**Consultation Response from KC,
Highways Development Management**

2023/91418 Woodhouse Quarry, Woodhouse Lane, Holmbridge, Holmfirth, HD9 2QR

Importation of infill materials to restore a former quarry

Date Responded: 04/08/2023

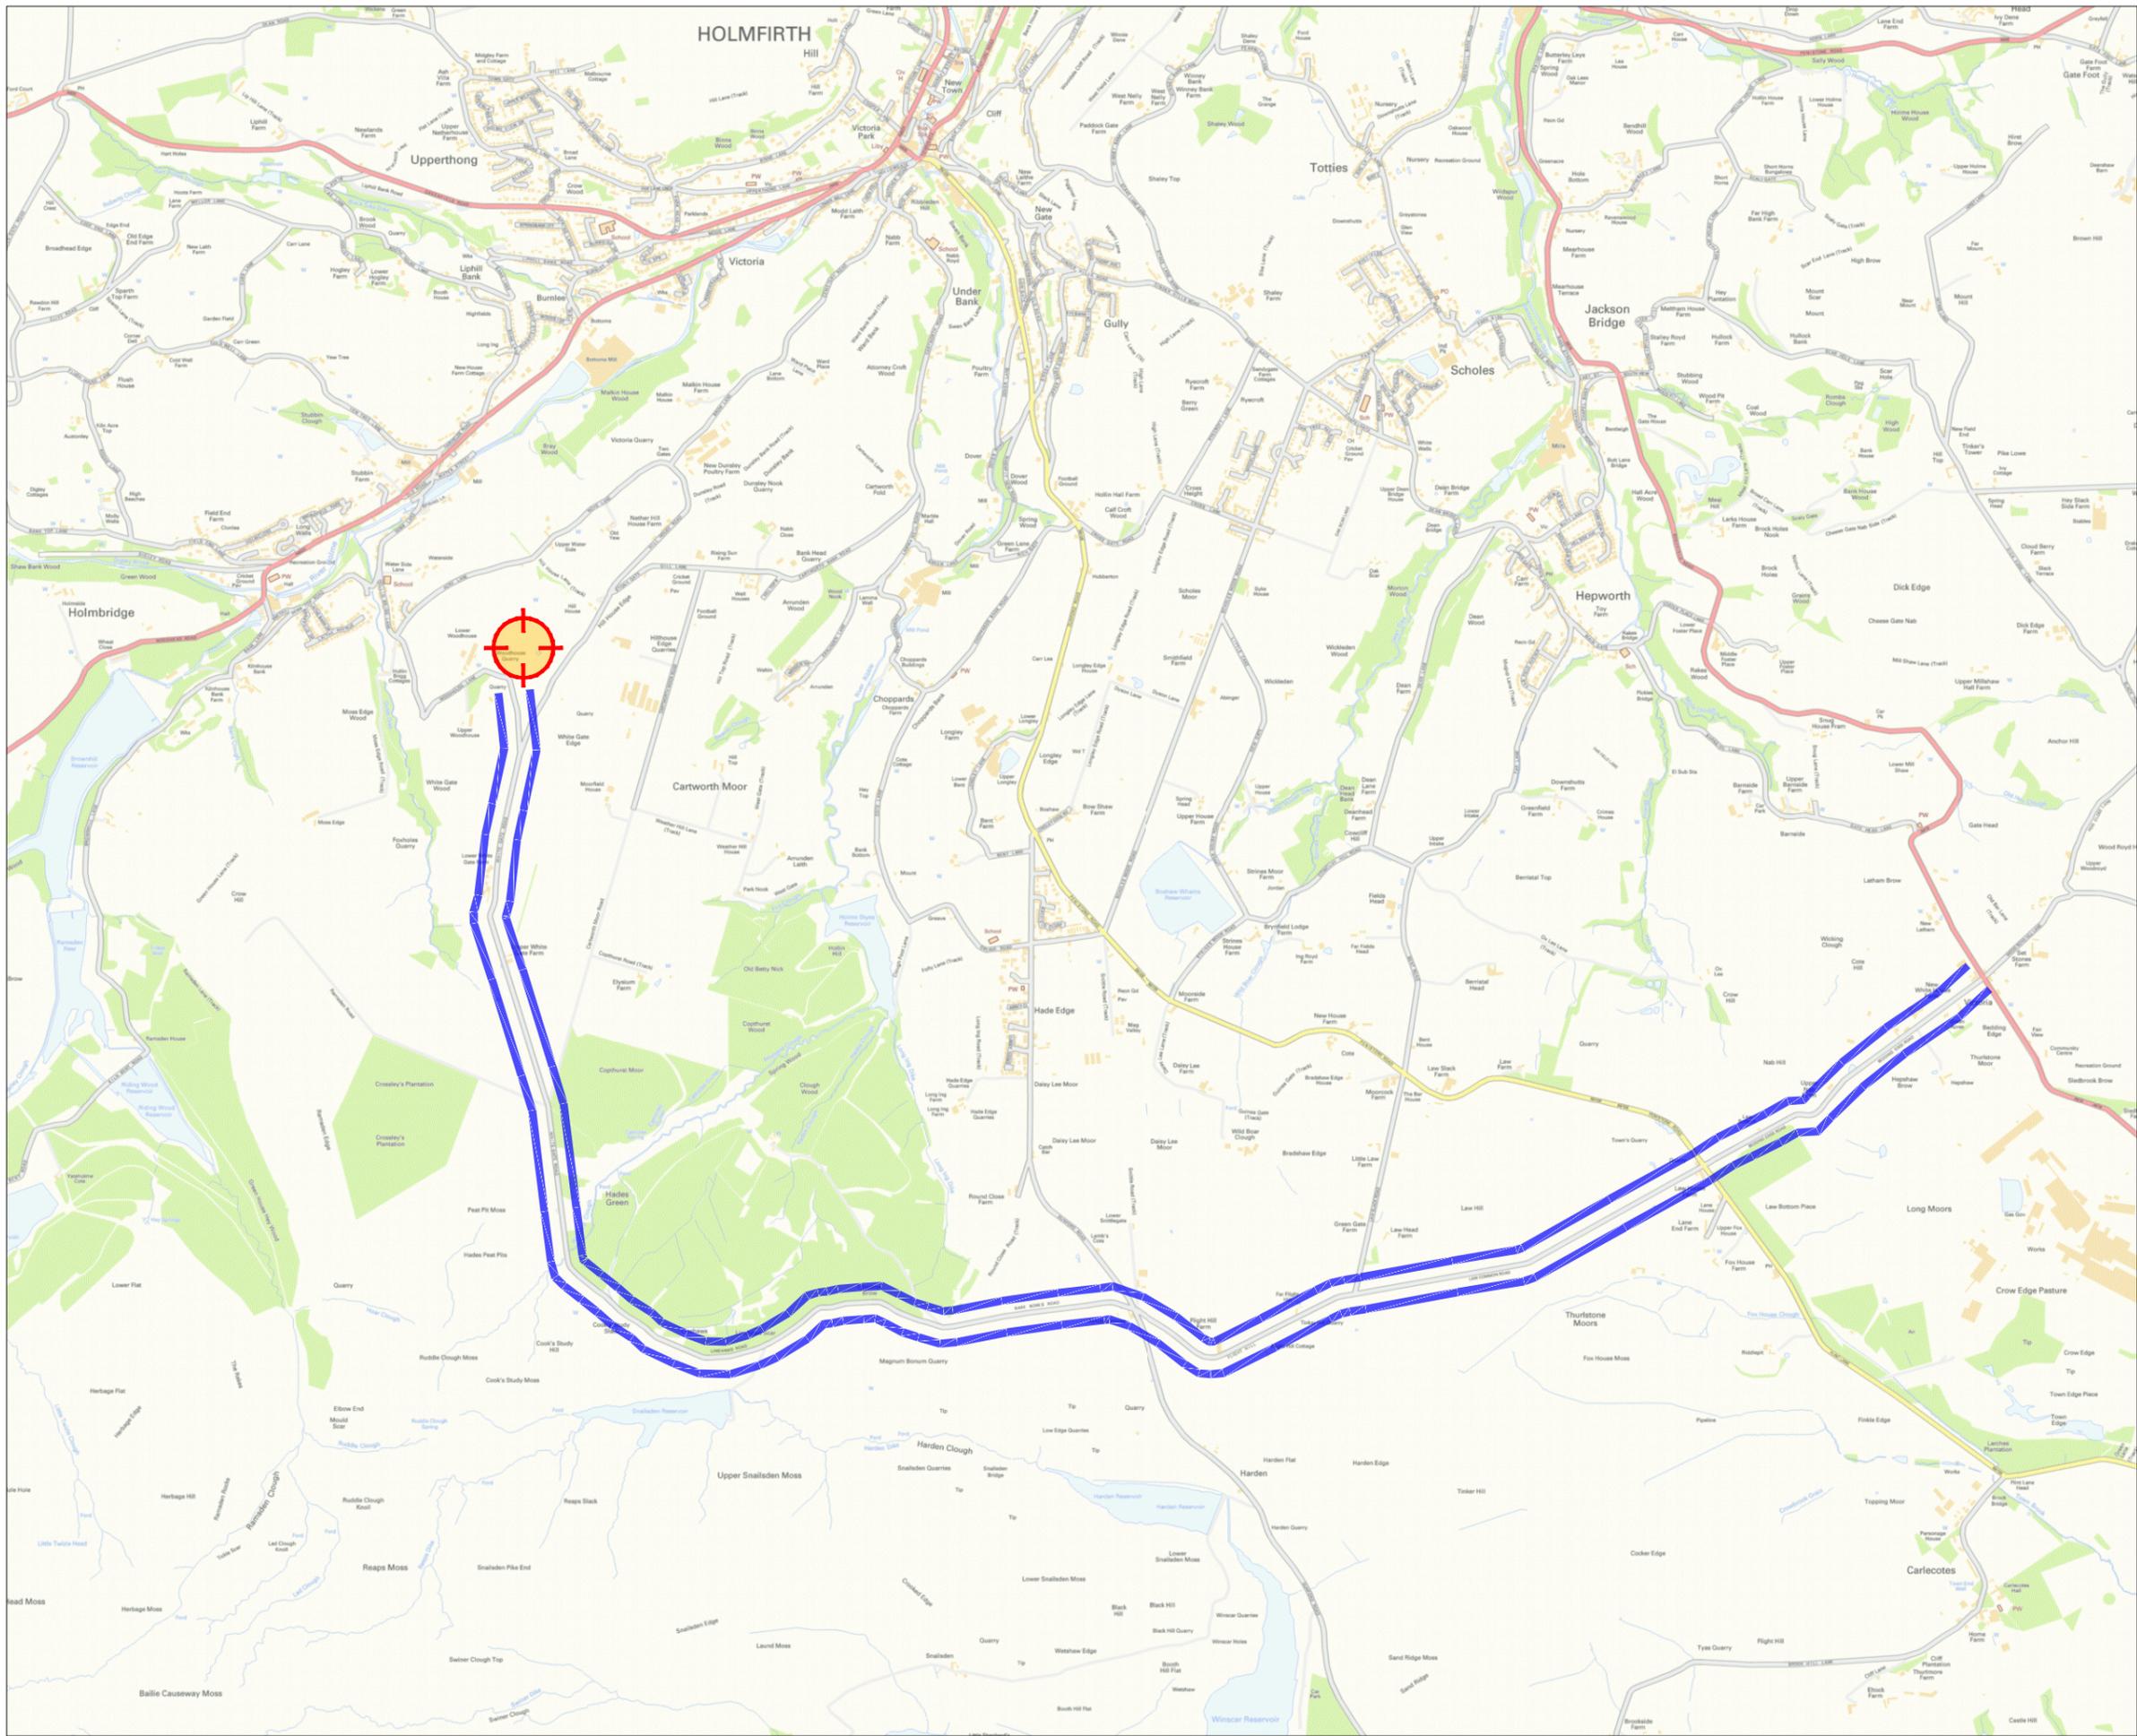
It is proposed to access the site via an existing dedicated vehicular access directly off Woodhouse Lane. The new access takes the form of a simple priority junction, a vehicle swept path dwg has been submitted of the largest vehicle expected to need regular access the quarry (see appendix D in the submitted TA. The junction provides good visibility in both directions with the existing access considered acceptable for the proposed use.
